Office of Environment & Heritage

MP 10_0135 MOD 3
DOC 14/252234
Virginia Thomas 6229 7105

RE: Modification 3 for Capital II Wind Farm – Overhead Transmission Line extension.

**Figure 1. Route of the Proposed Transmission Line.**  
Dashed green line indicates the route.

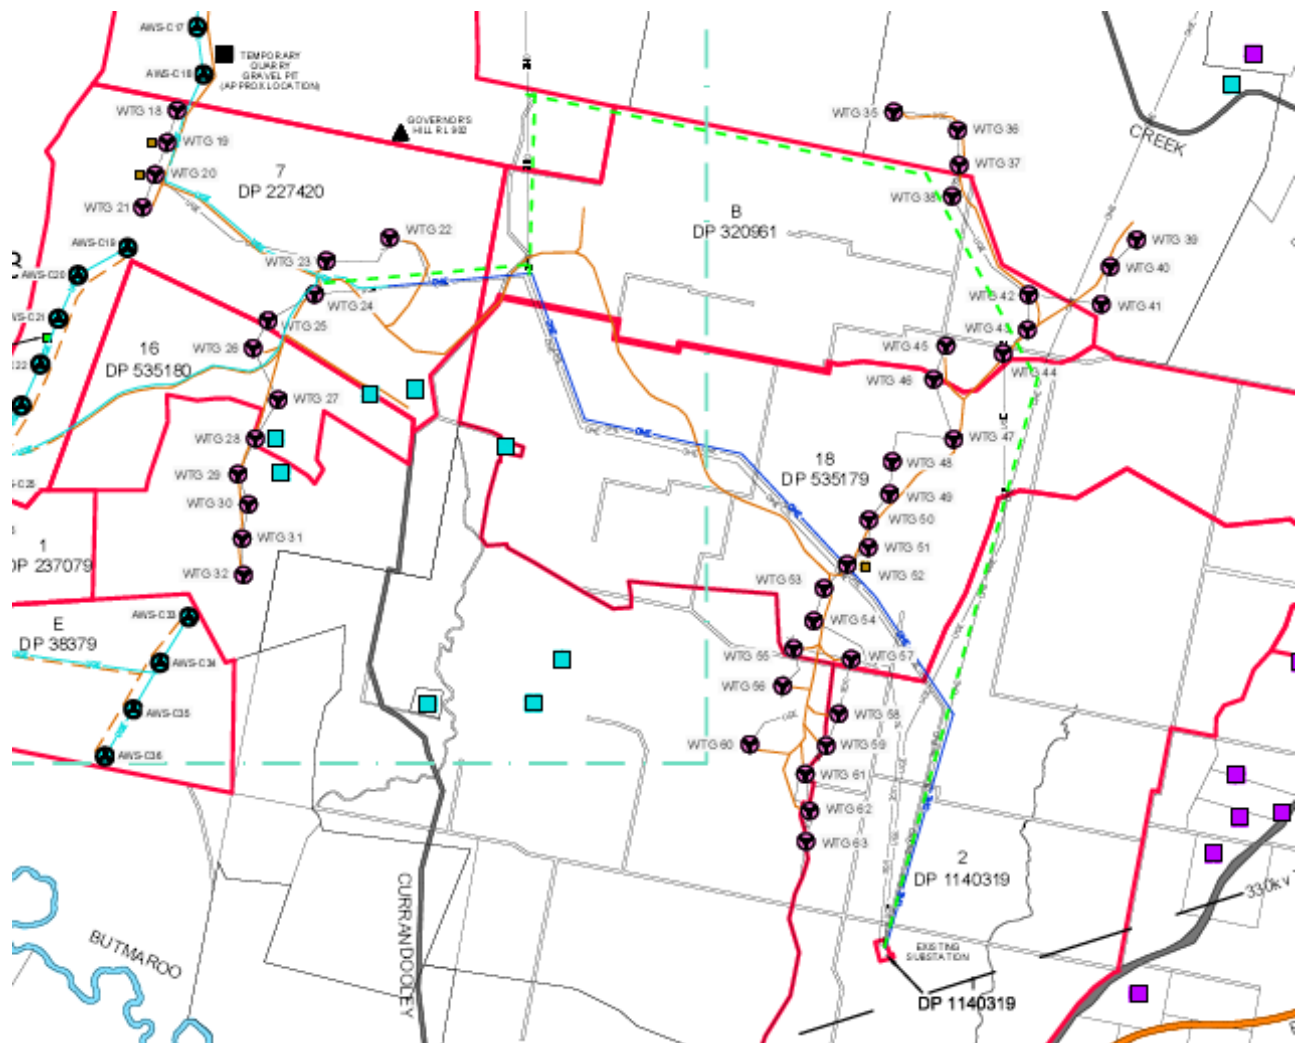
OEH advises that the Aboriginal heritage assessment, dated 24 September 2014, provided as part of Modification 3 is currently inadequate to consider whether the overhead transmission line (OHL) will not impact upon Aboriginal heritage.

Whilst Austral Archaeology undertook an Aboriginal Archaeological and Cultural Heritage Assessment of the overall Capital II Wind Farm study area in 2005; OEH advise the section relevant to the proposed OHL was not surveyed. This is problematic because the landform type conforms to one of the criteria identified as having archaeological potential whereby: "sites are most likely to occur on lower slopes and alluvial landforms" (Monteath & Powys P/L correspondence 24 September 2014 p2). OEH acknowledge that a comprehensive search of AHIMS was undertaken which did not find any sites in close proximity to the proposed OHL. This is however most likely due to the area not having been systematically surveyed. As such, OEH is concerned that the current assessment submitted has not adequately determined the impacts of the proposed Modification on Aboriginal heritage values as part of the assessment process and as such it cannot be conclusively demonstrated that Aboriginal objects are absent from this area.

As an indication of the archaeological potential; OEH advises that the Aboriginal site "Nardoo" (AHIMS # 57-3-0001) is a stratified subsurface deposit located approximately 3km

east/northeast of the proposed OHL. The site has been dated to 800 years old and contains high densities of artefacts including backed blades. A large section of the proposed OHL occurs on a similar landform type. The 2005 assessment by Austral Archaeology (page 17) also supports this whereby it states:

Given there is currently no Indigenous Heritage Management Plan prepared for the Capital II Wind Farm project, OEH recommends a more formal survey of the proposed OHL should be undertaken to confirm there will be no impacts to Aboriginal heritage values. Consultation with the registered Aboriginal stakeholders should also form part of the assessment given the cultural values and significance of the area previously identified by Aboriginal community representatives.
